Angmering Parish Council

PLANNING APPLICATION A/99/17/OUT LAND SOUTH OF WATER LANE, ANGMERING

OBJECTION

Proposed Site Access Plan

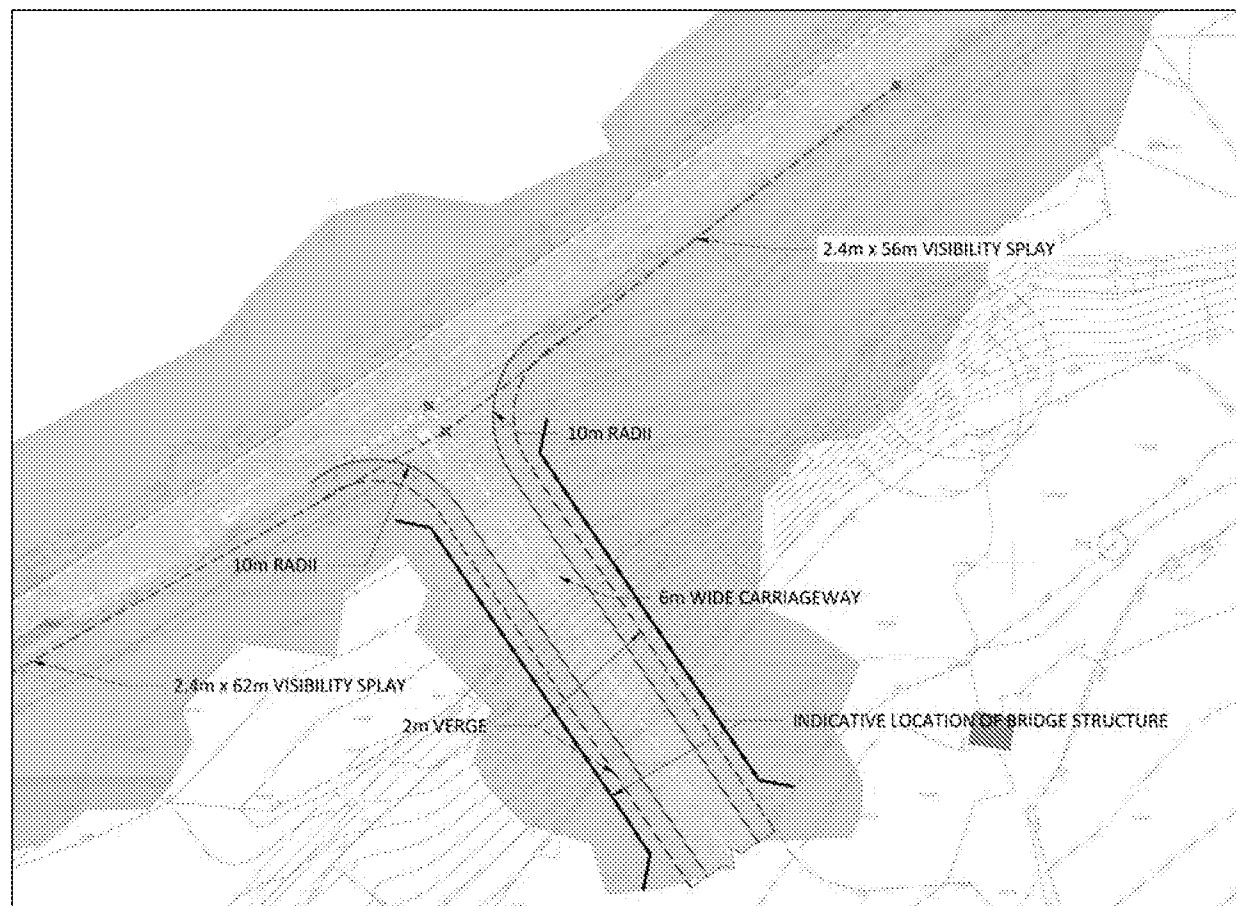
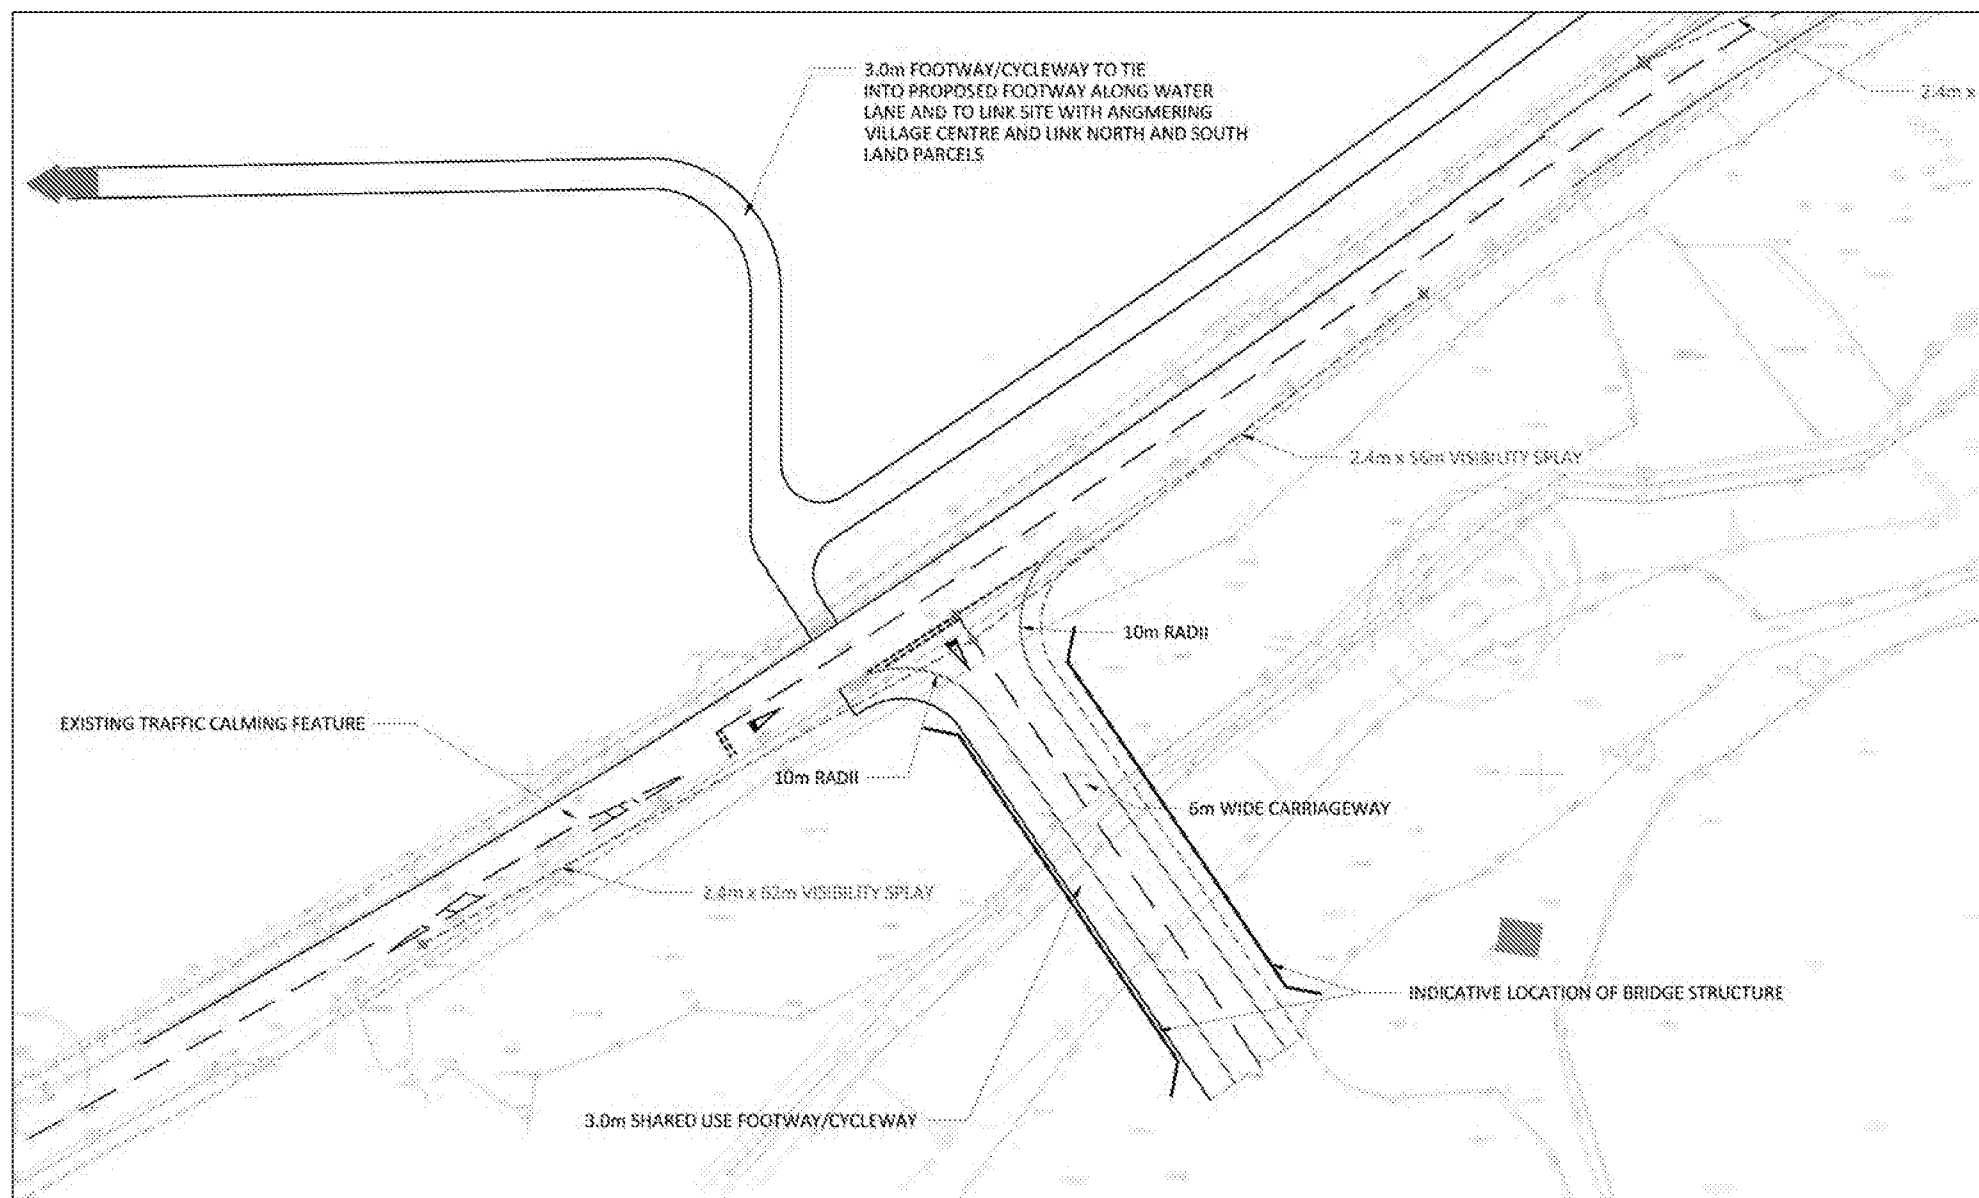
The application does not explain what the bridge will look like; how it will span the Black Ditch or how its construction or timing relates to any solution required to mitigate against the potential flood risk to others from the larger "Strategic" site north of Water Lane and therefore not prejudice its delivery.
